BRASHER & LORENZ, INC.
CONSULTING ENGINEERS

July 5, 2001

SUBJECT: GRADING & DRAINAGE PLAN FOR BAGLEY STUDIO
J-14/D140

BAGLEY STUDIO
GRADING & DRAINAGE PLAN

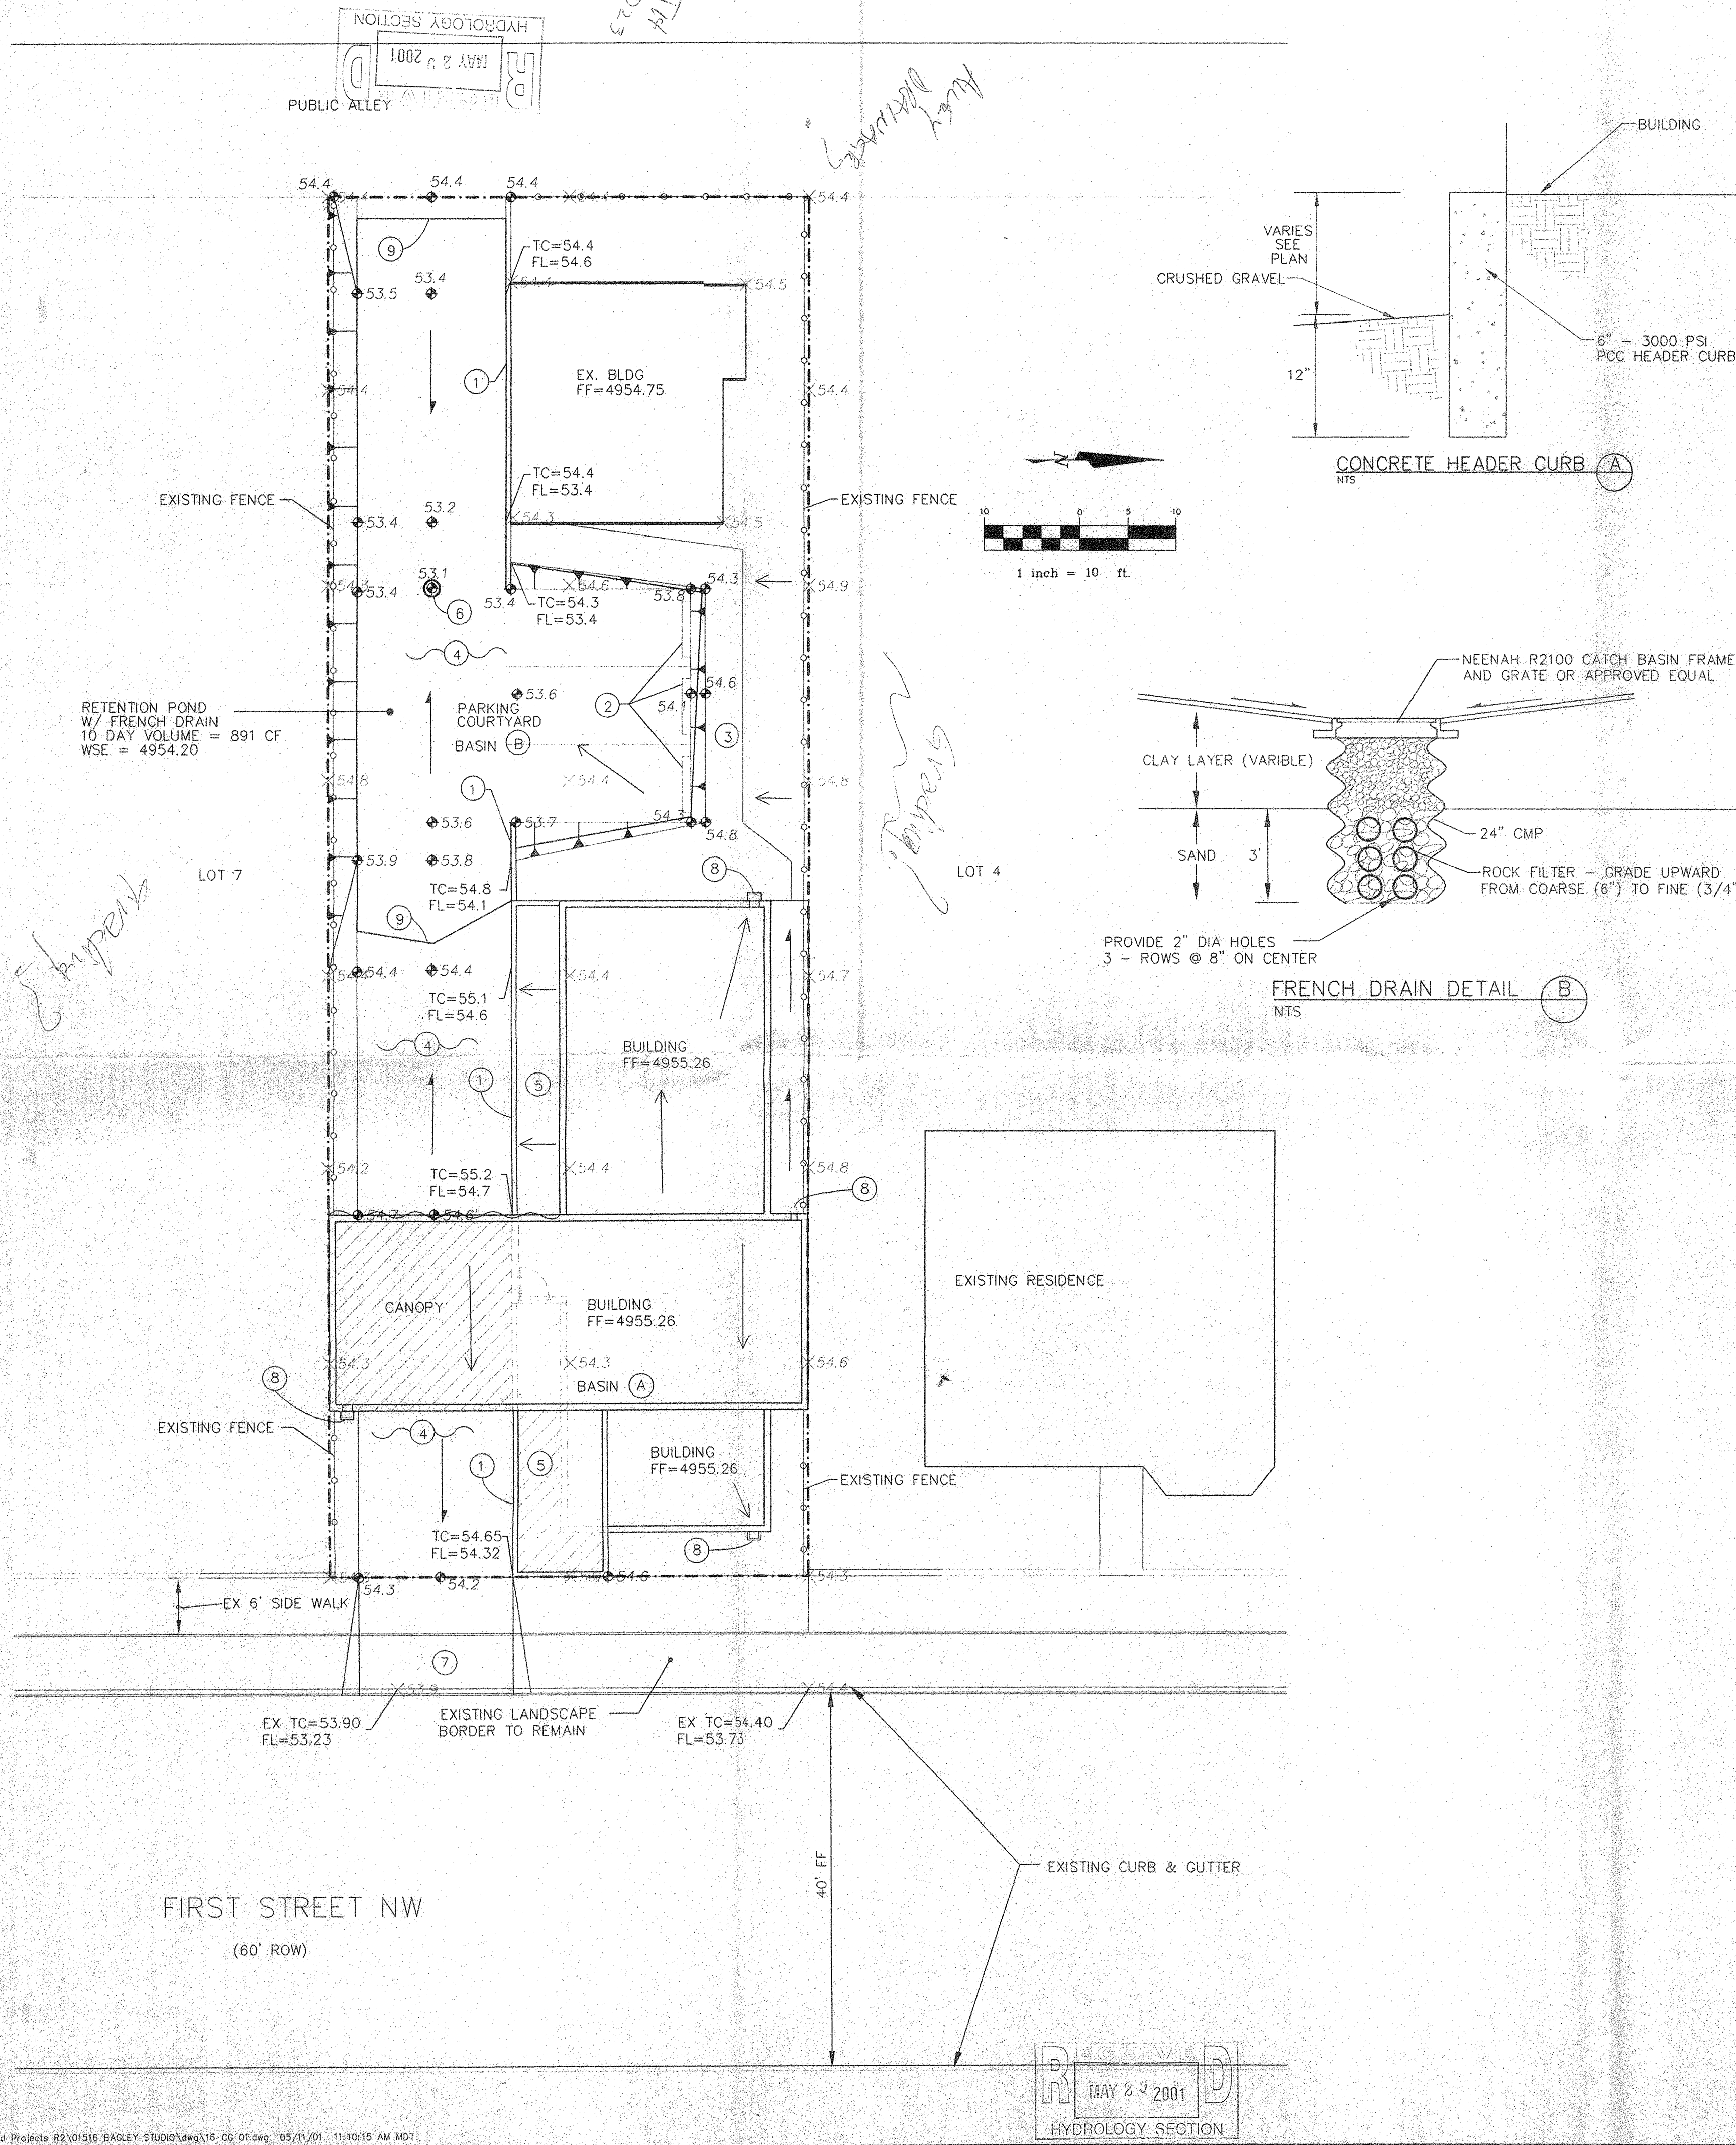
Submitted herewith are 2 copies of the revised Grading and Drainage Plan for the subject project. The Plan has been revised to eliminate the French drain concept and instead recommends an area drain that connects to the public 18-inch storm drain in First Street. I've discussed this with Loren Miens, and he feels it can be permitted through the SO#19 process.
